DECISION DELEGATED TO HEAD OF PLANNING

Application No: H11-1009-25 **Applicant:** Mr & Mrs Lockyer
Proposal: Proposed Sun Room Extension
Location: 4 Daniels Gate Long Sutton Spalding
Terminal Date: 26th December 2025

SCALE as shown at A1
DATE OCT 2025
DRAWN STB
DRAWING NO
350 - 01

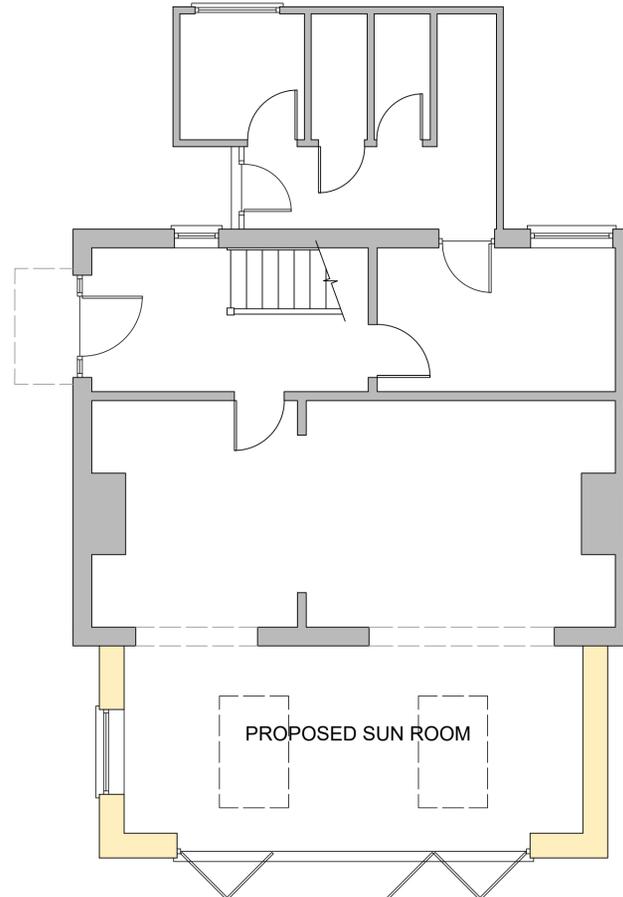
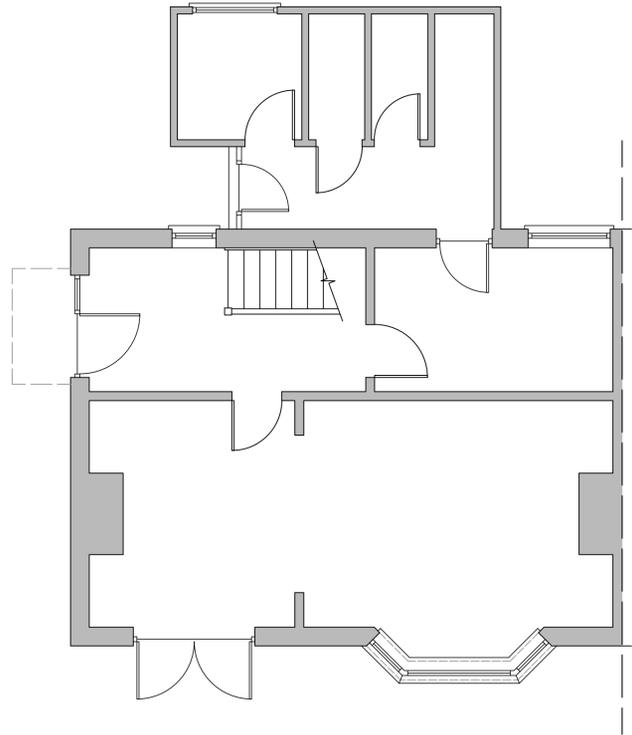
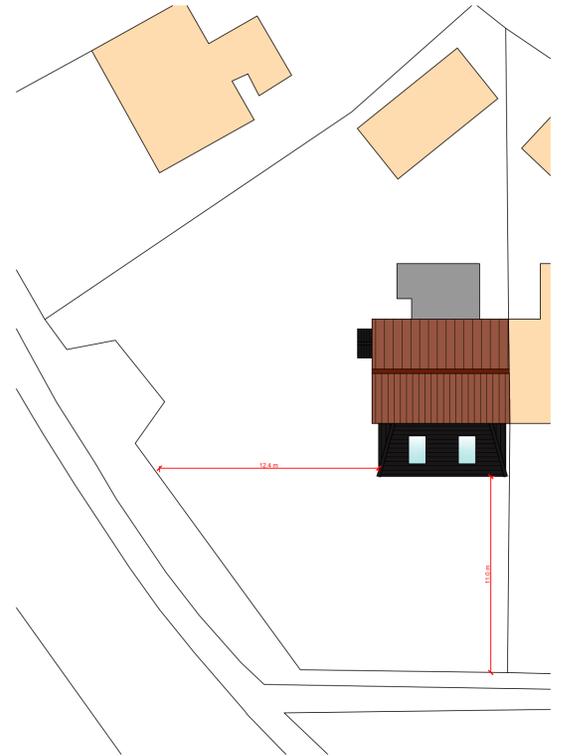
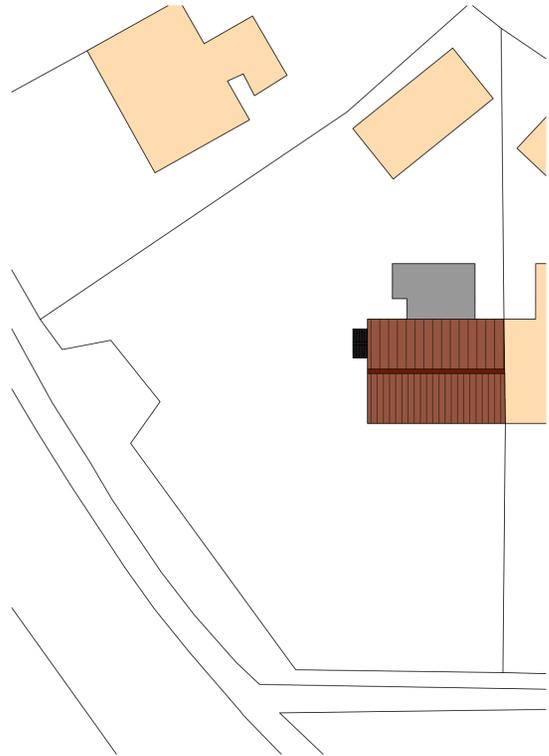
The layout of the property within the plot results in the extension protruding from the front elevation, this is reinforced under drawing number '350-01' which labels the extension on the front elevation.

As a result of this, the extension would be visible and would become increasingly readily visible, should the existing hedging be reduced in height at any point going forward. The proposed addition, given its siting and visibility, would cause harm to the street scene and locality despite being mostly concealed from view due to the extant hedge along this boundary as existing.

In regard to the existing hedging, it has been noted that as recent as 2016, the hedge was significantly lower and showed the entire front of the plot and front elevation. If this was to be returned to this state, it would provide no concealment for the extension. No other examples of a front extension are visible along Daniels Gate meaning no justification could be made through this.

As a result, the siting of an extension on this front elevation would cause significant and unacceptable harm to the street scene and locality and should be refused for this reason.

Notwithstanding the above, the proposed brickwork would match the host dwelling, with the roof tiles comprising a different material to that of the host; although, these are not of such materially significant difference as to warrant a refusal in this instance. As such, the extension would not cause any material harm to the street scene or locality, in respect of the material finish proposed.

The extension would be sited directly adjacent to the neighbouring boundary and therefore could cause some overshadowing concerns. In any case, any overshadowing would be of very low levels and not a direct material impact. A shadow could only be cast when the sun is setting and its latest point in the day when naturally the light levels are at their lowest. Furthermore, due to the proximity to the neighbouring dwelling no window is located on the side elevation which faces this. As such, no material overlooking should occur either.
